Your Ref: OWPC22195
Our Ref: FG/220/18/PL 17-12-2018
Please ask for:
Andrew Wood

Erection 1 No. dwelling with integral garage.
Land adjacent to Elm Lodge Tamarisk Way Ferring

Thank you for your internet representation made on 13th April 2019 which has been recorded as '**an objection**' with the comments as follows:

Drawing Title **PROPOSED POND ACCESS
PLAN**

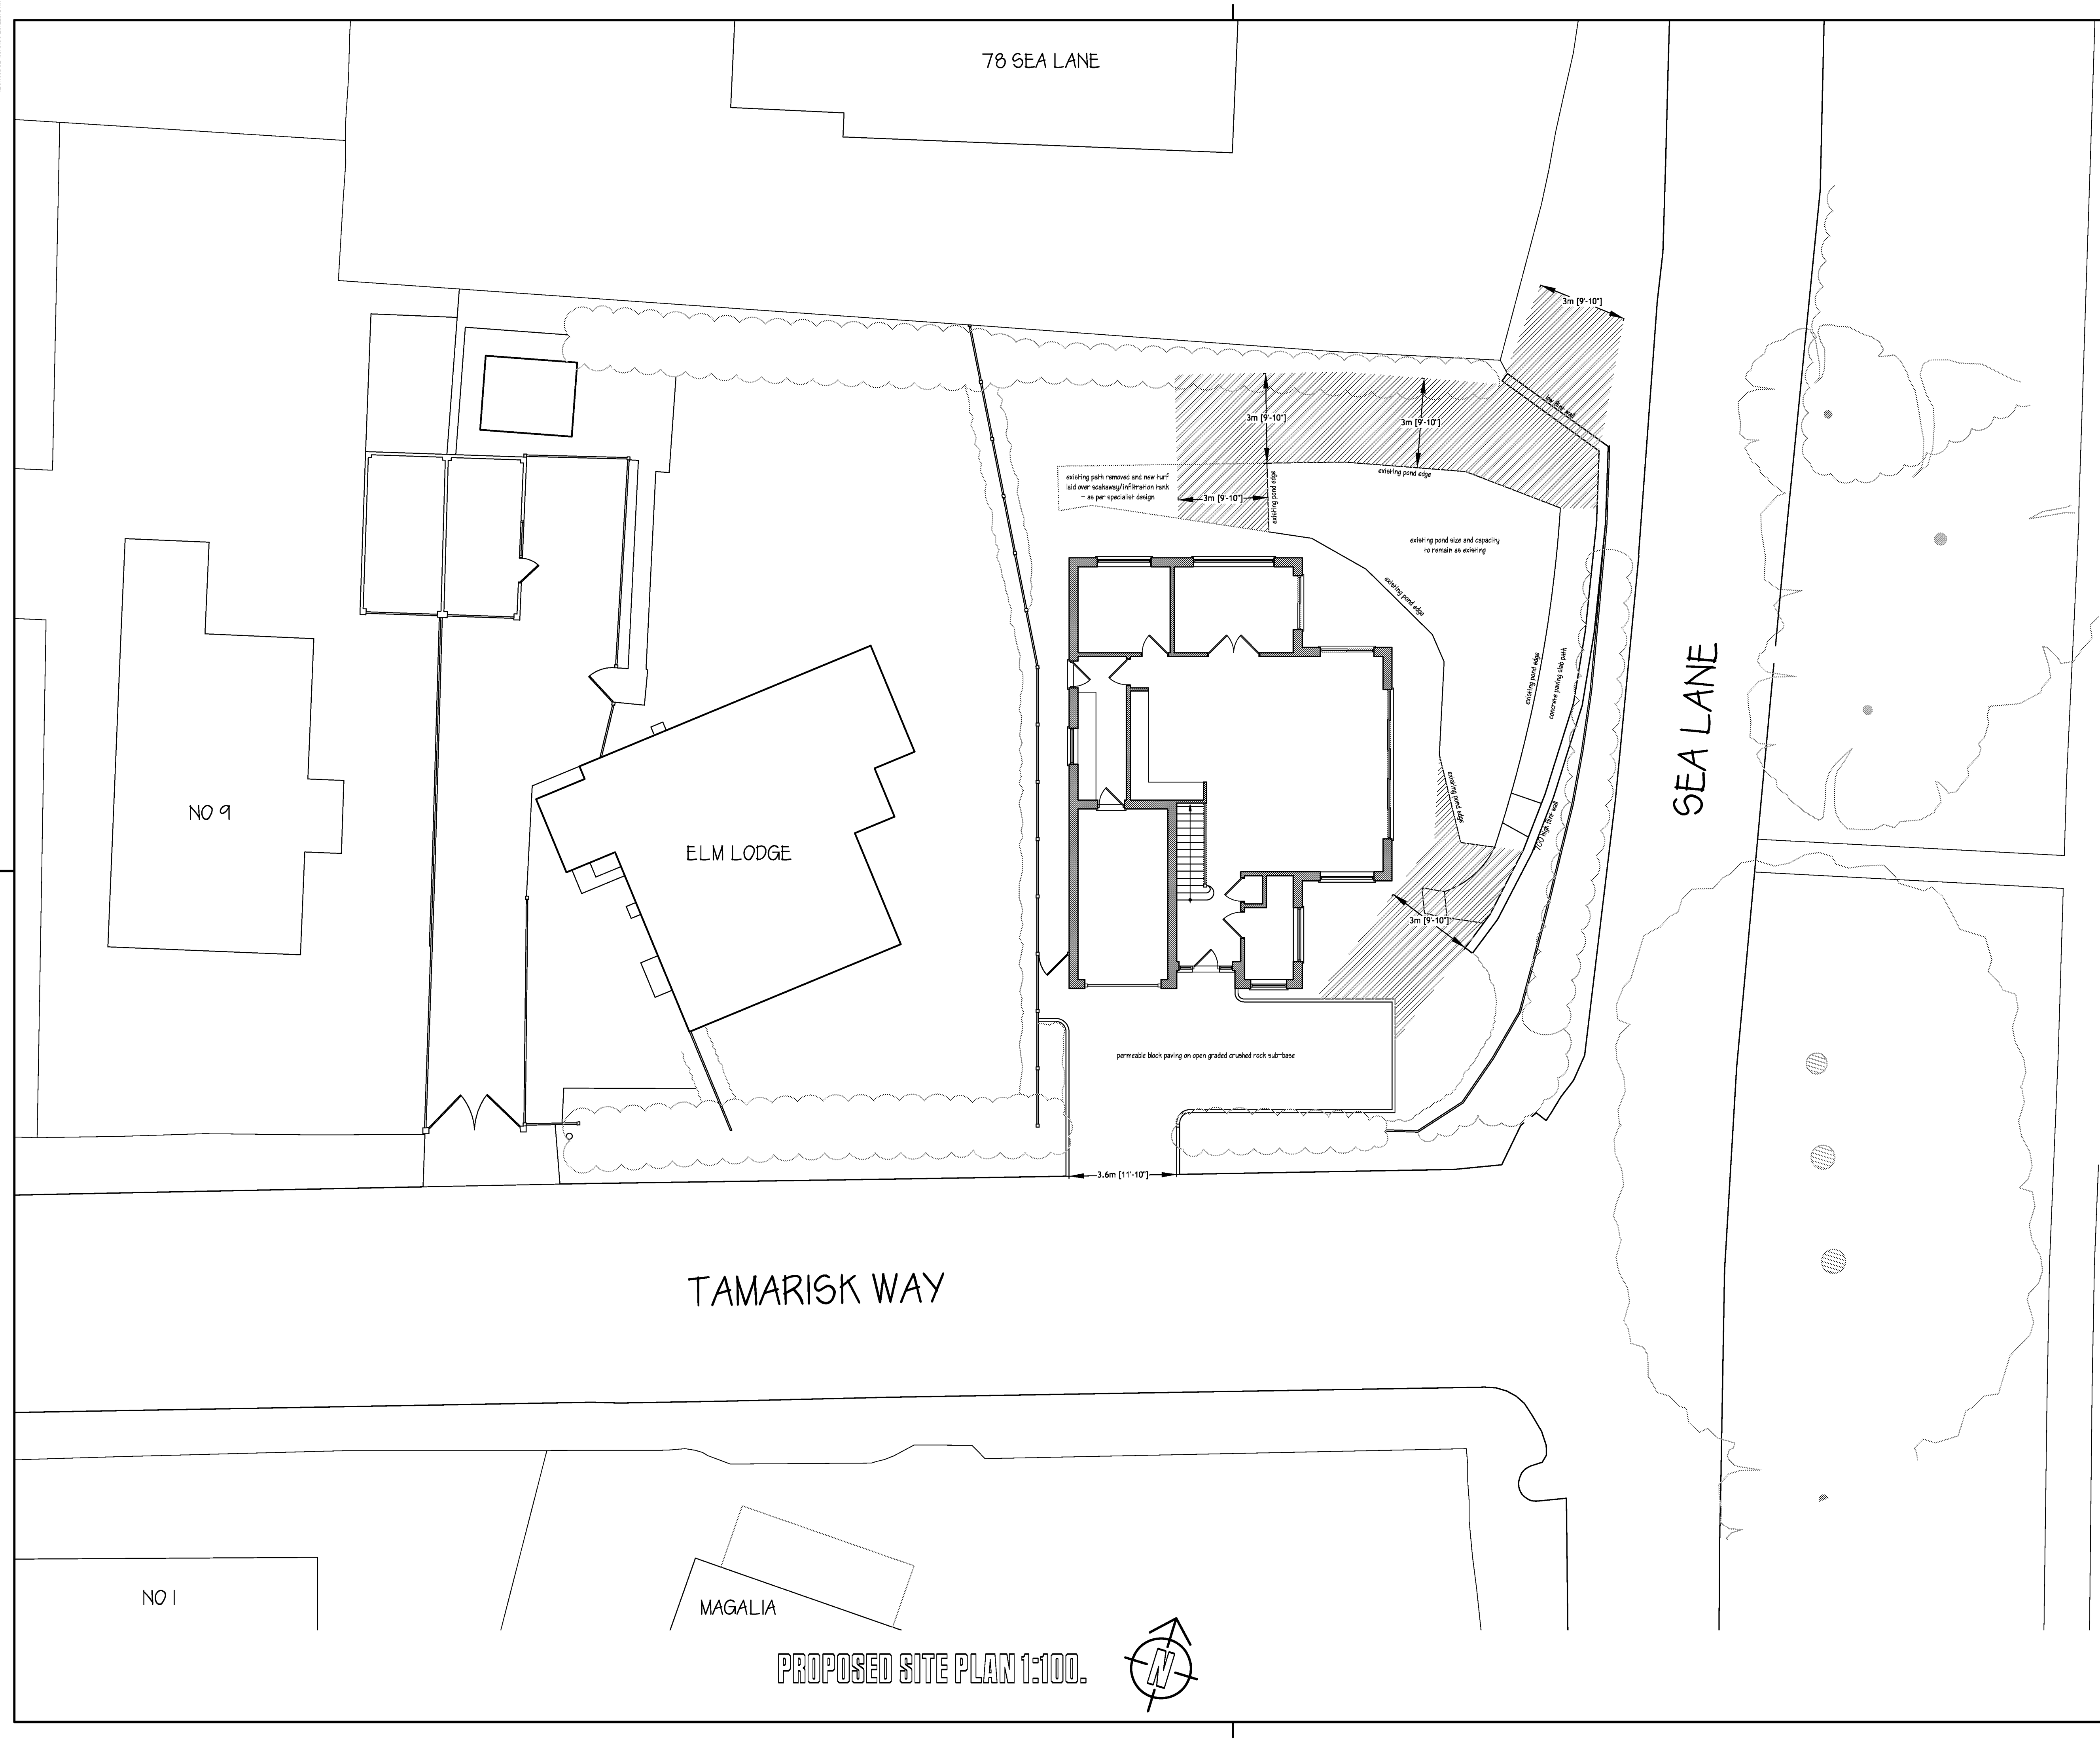
As a result of leaving the minimum space required around the pond for maintenance, the proposed house is now shown to be closely positioned next to Elm Lodge creating a cramped appearance.

The conservatory at Elm Lodge would have to be demolished in order to squeeze the proposed house into the limited space available.
